Our Ref: LU/45/20/PL

**Town & Country Planning Act 1990 (as amended)
Town and Country Planning (Development Management Procedure) (England) Order 2015
Application for Planning Permission**

Development Change of use of existing ground floor retail unit (B1Business) to 3 No. flats (C3 Dwelling houses).

Location Ground Floor unit Saltmarsh House Old Market Lane Littlehampton

PROPOSED GROUND FLOOR PLAN & PROPOSED ELEVATIONS

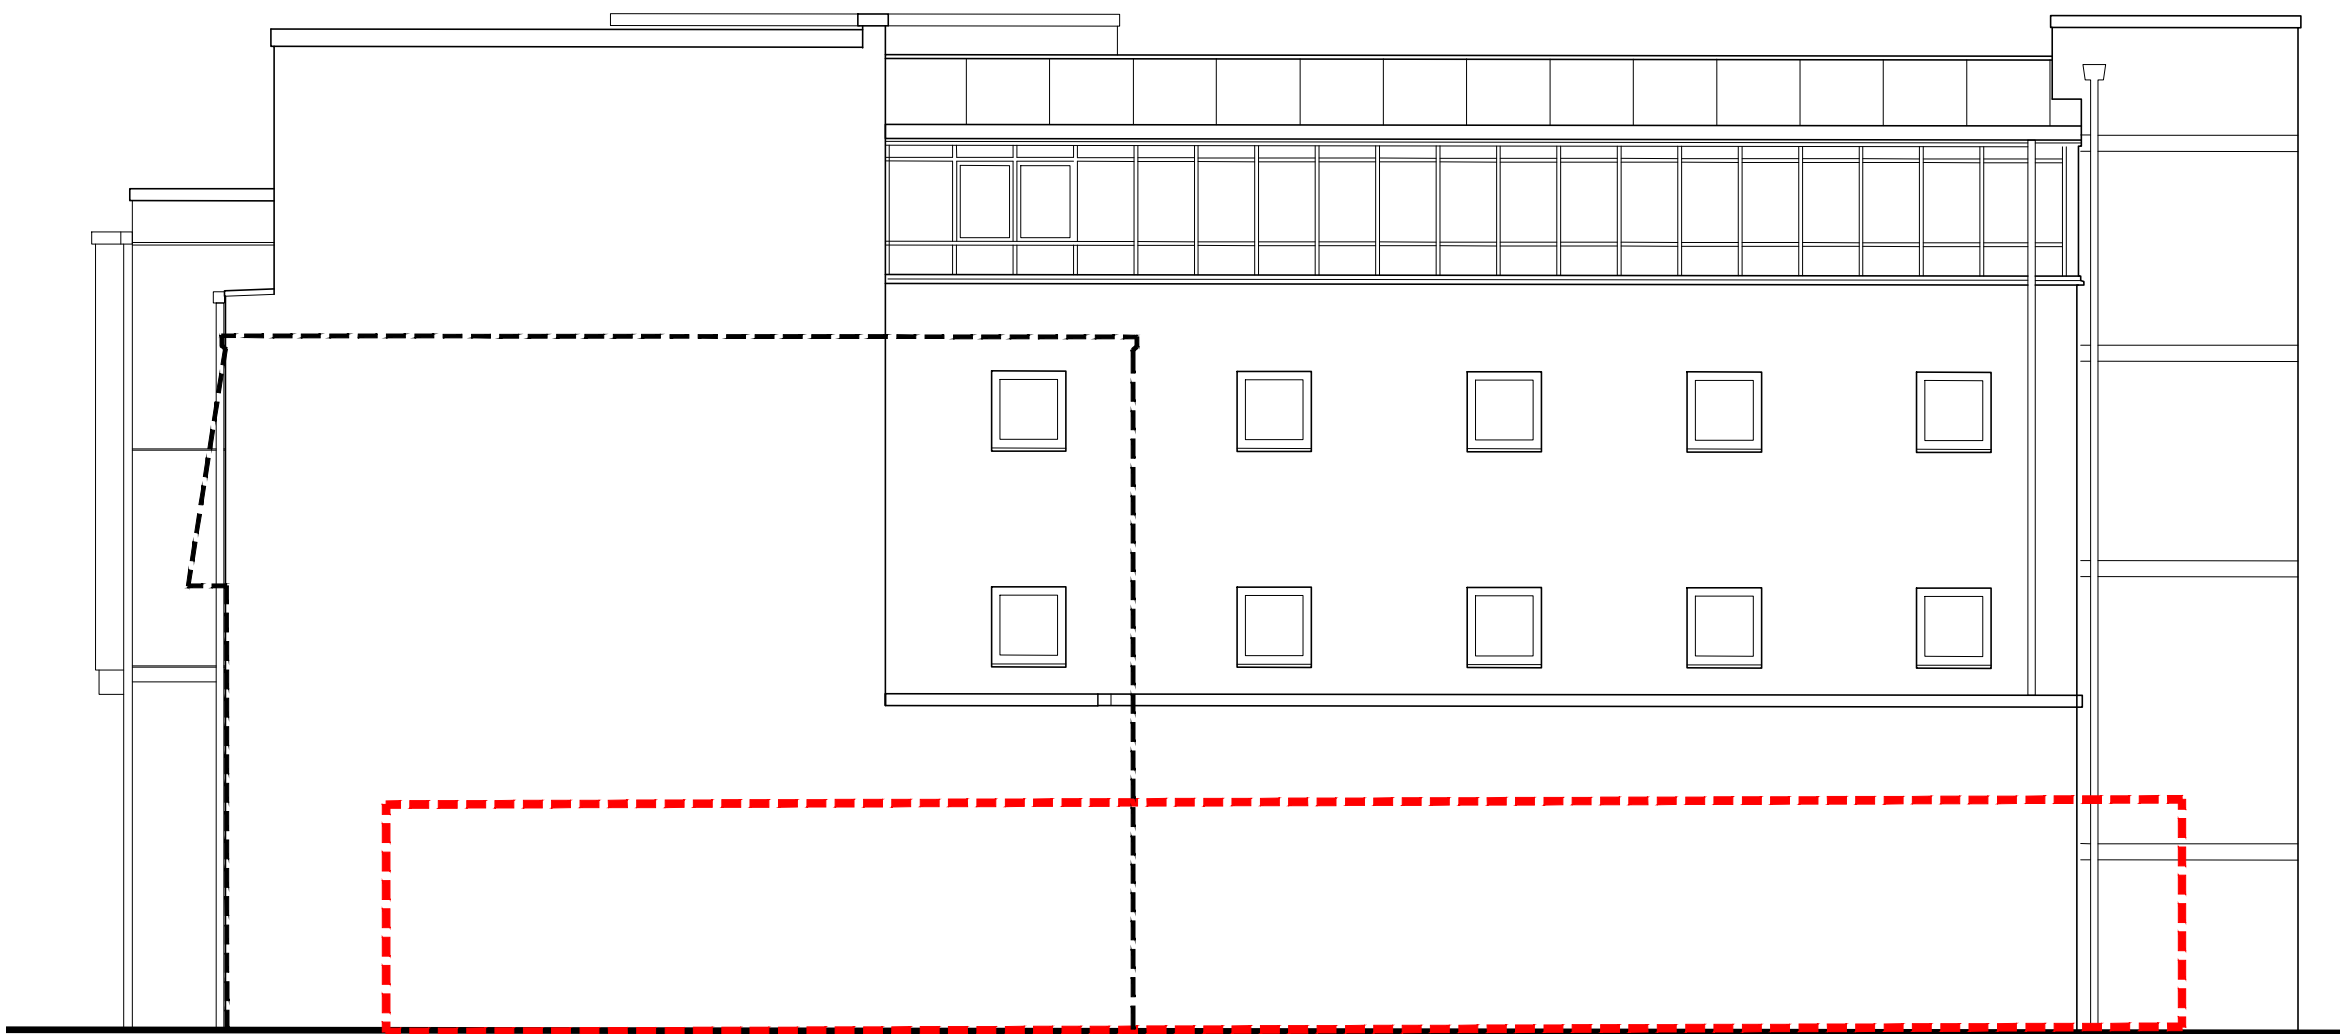
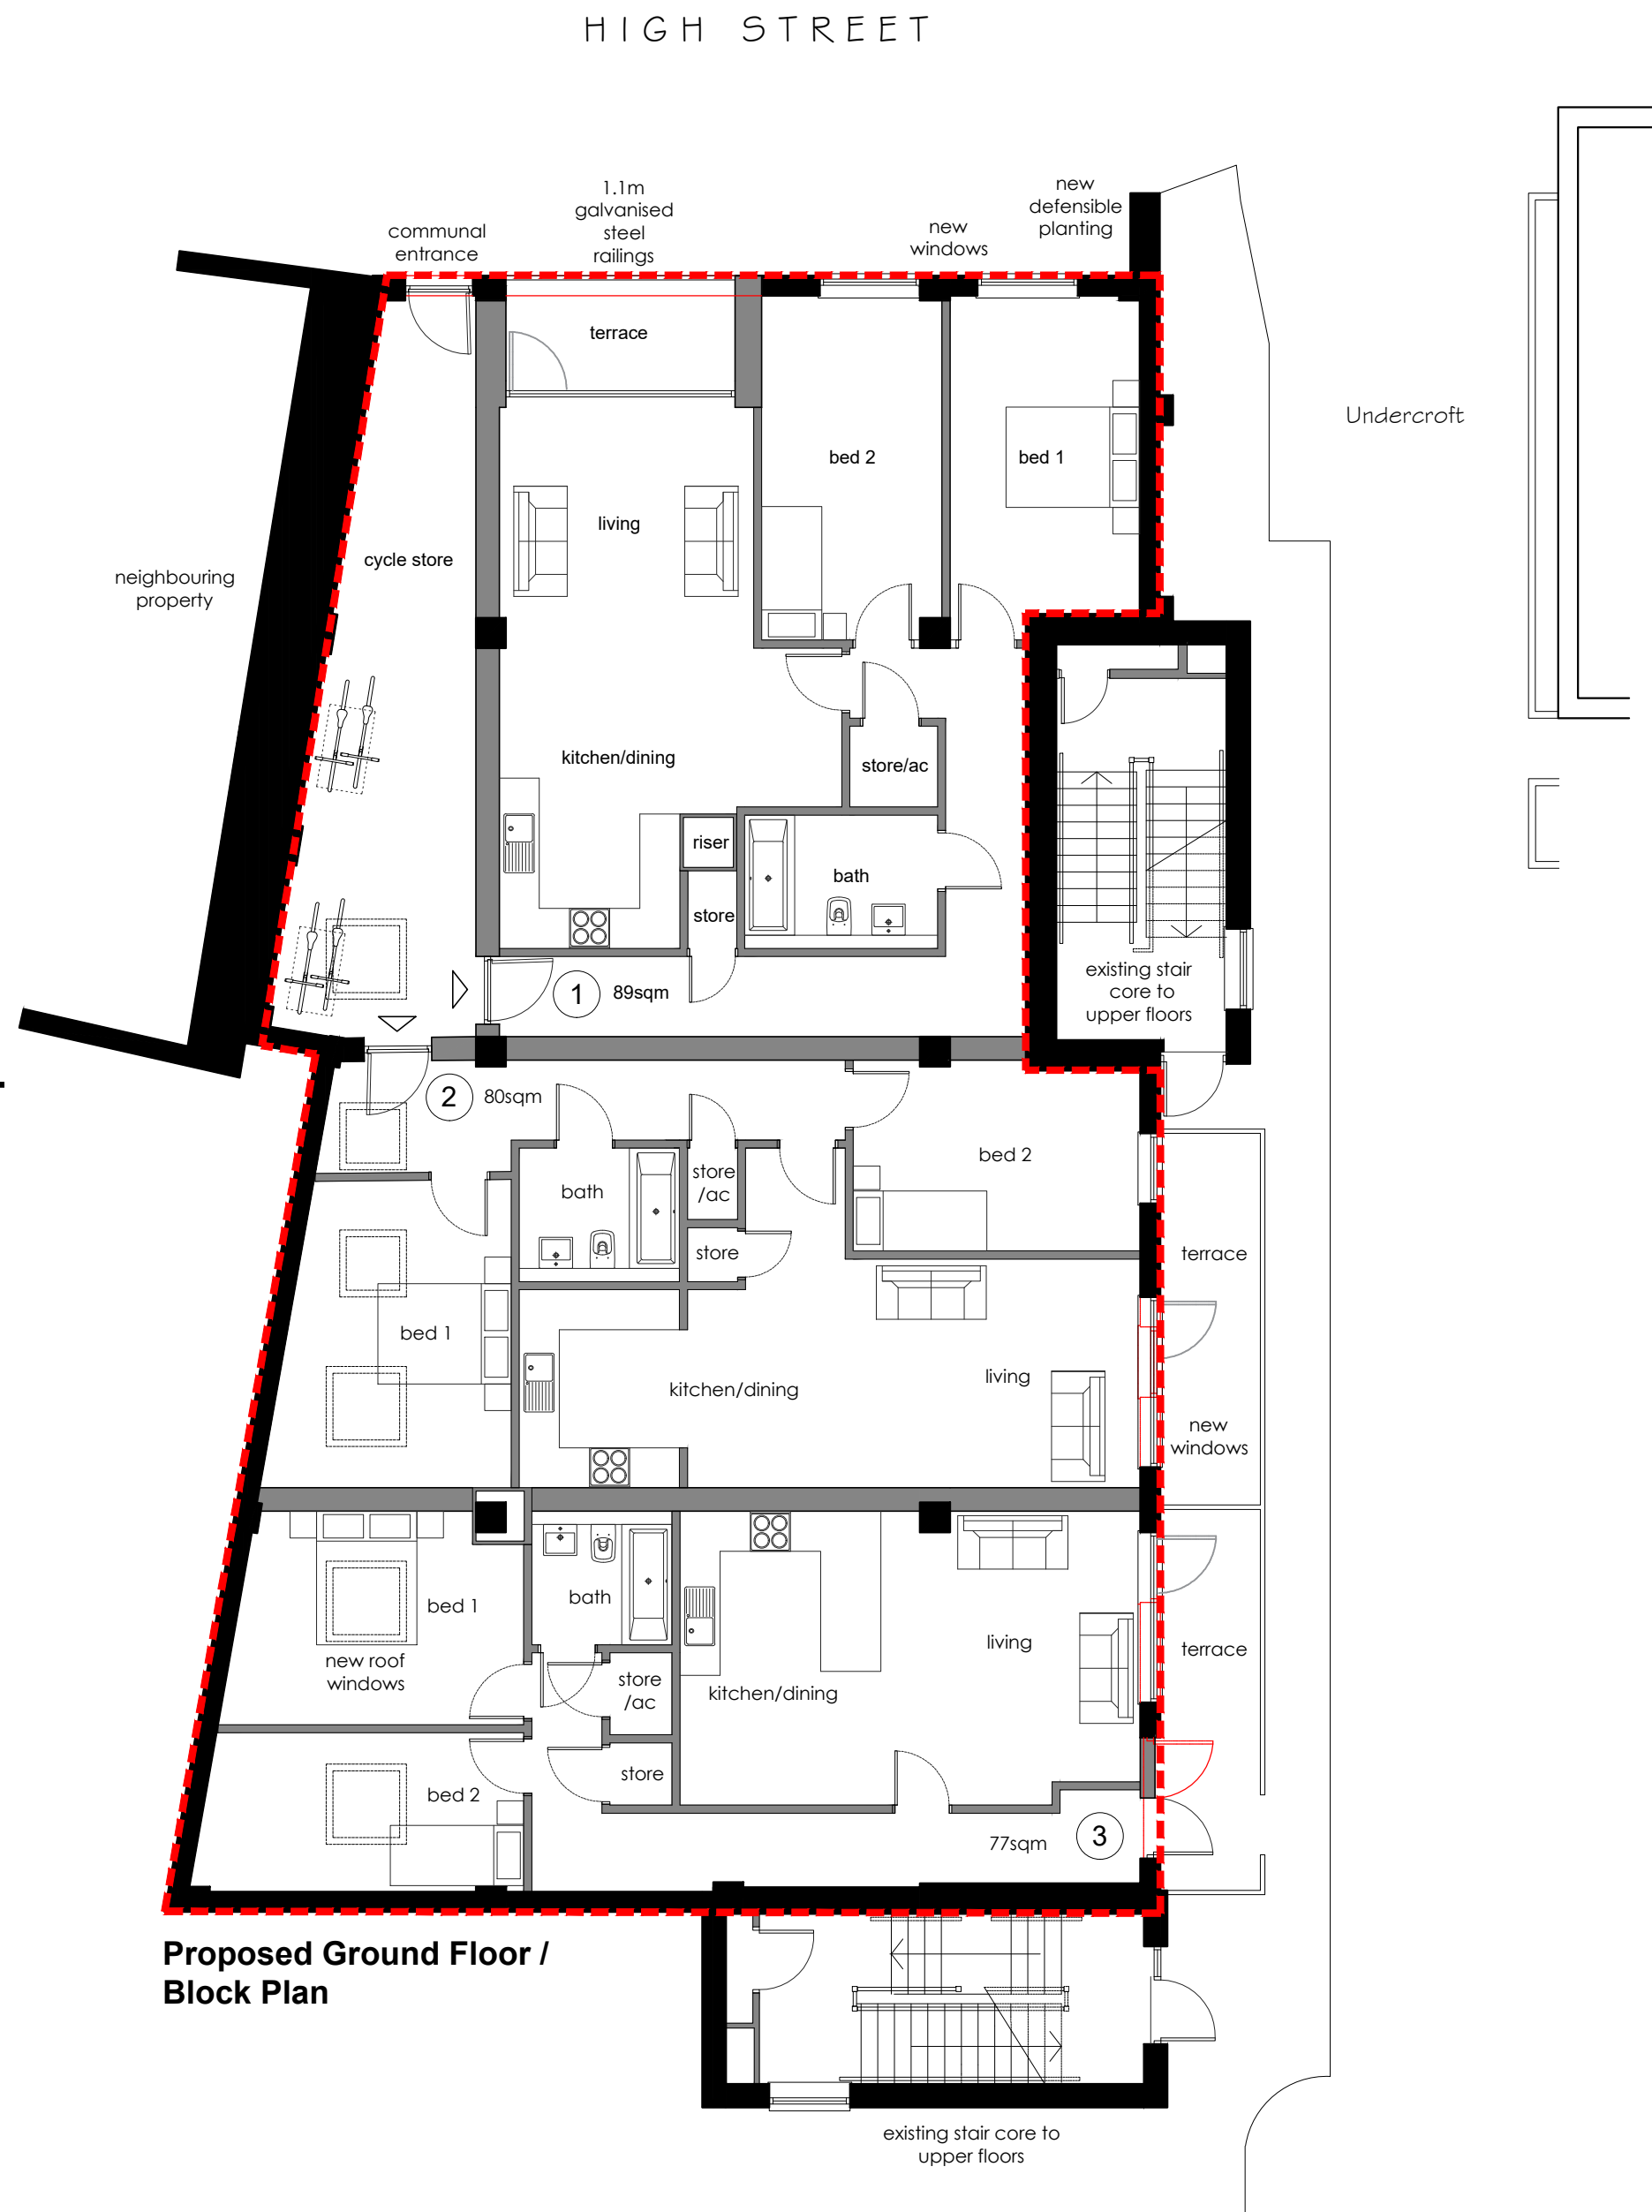
The existing and proposed ground floor plan and East elevations do not accord. Please amend accordingly.
